# Rezoning Transportation Analysis

Petition Number: 2021-112

General Location Identifier: 04723122, 04723120, 04723123, 04723124, and portion of 04723113

From: **Brandon Brezeale, PE**

RZ-2: PARCEL IDENTIFICATION PLAN

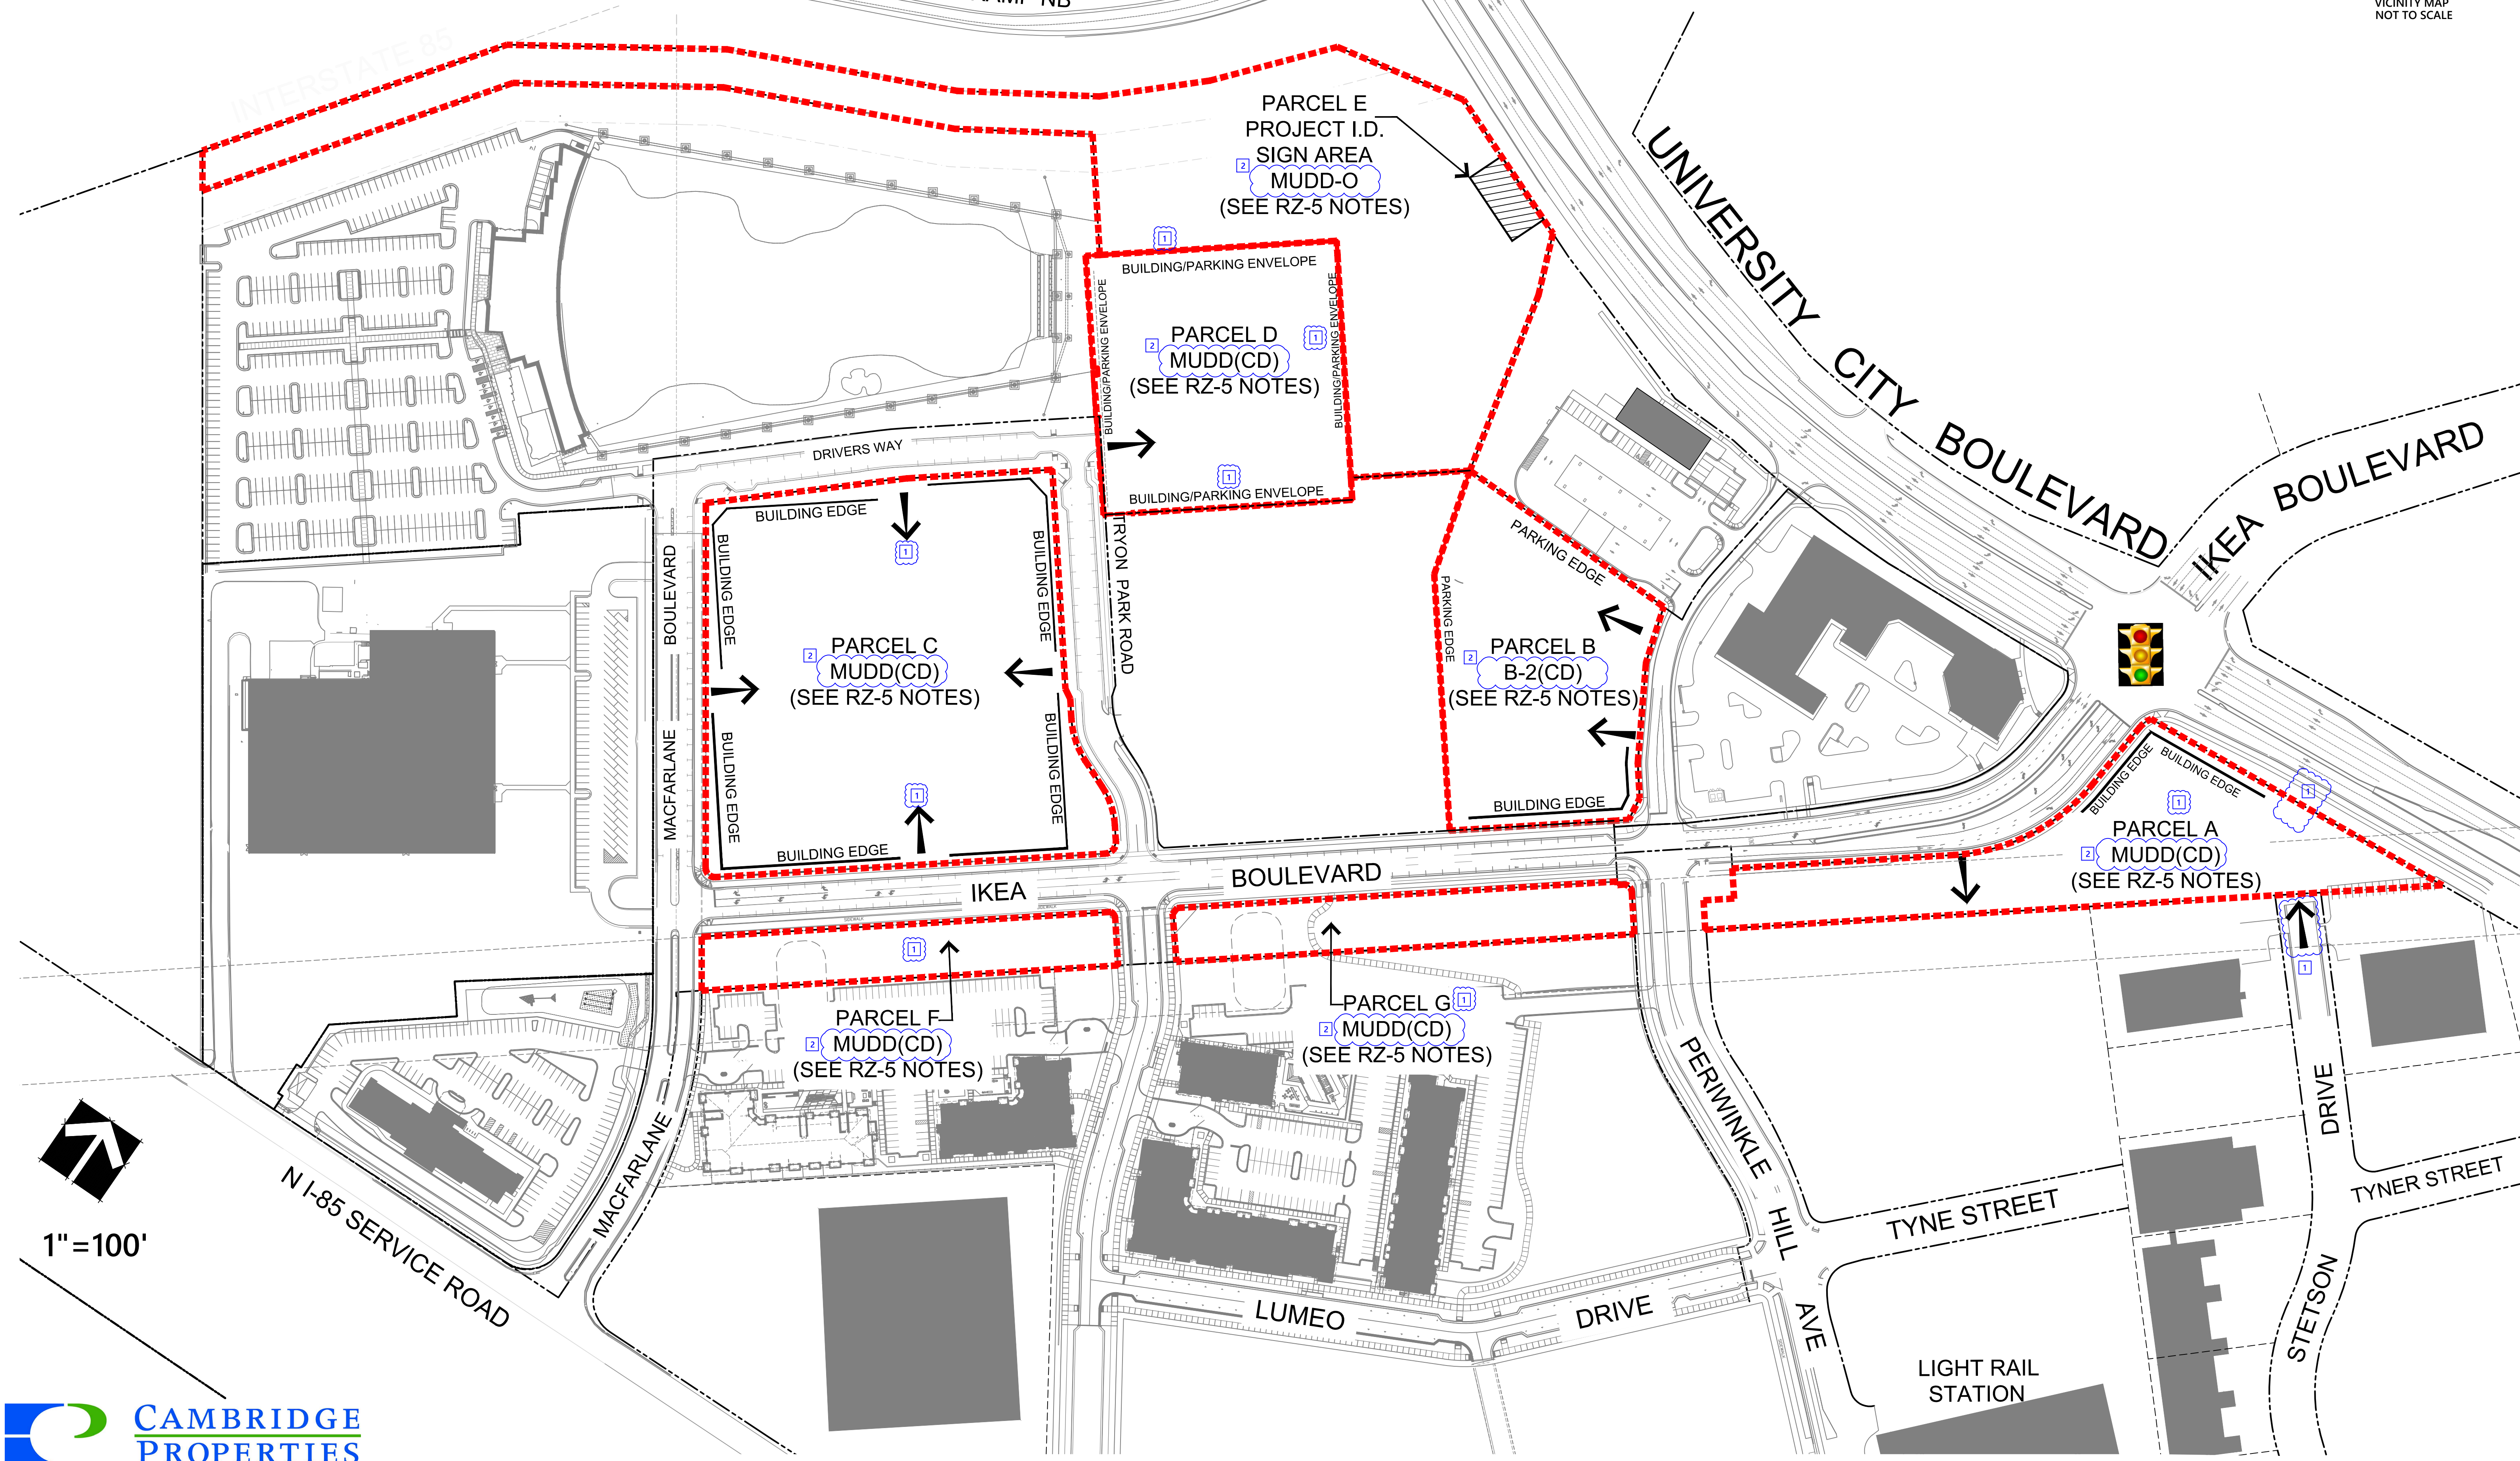
5. **New Comment 3.24.2022:** Revise site plan and conditional notes to commit to installing 8-foot planting strip and 8-foot sidewalk along all public road frontages with no existing sidewalk or along road frontages where the sidewalk is substandard per Chapter 19 ordinance.

**Follow Up to Comment 4.19.2022:** The existing sidewalk on Periwinkle Hill fronting Parcel B is substandard and needs to be replaced with an 8-foot planting strip and 8-foot sidewalk.

6. **New Comment 3.24.2022:** A site plan note(s) specifying dedication and fee simple conveyance of all rights-of-way to the City before the site's first building certificate of occupancy is issued as needed. CDOT requests rights-of-way set at 2' behind back of sidewalk where feasible.

**Follow Up to Comment 4.19.2022:** This comment is outstanding and needs to be added to the conditional notes. The sidewalk installations described in #5 follow up comment will need SUE dedicated for future maintenance.
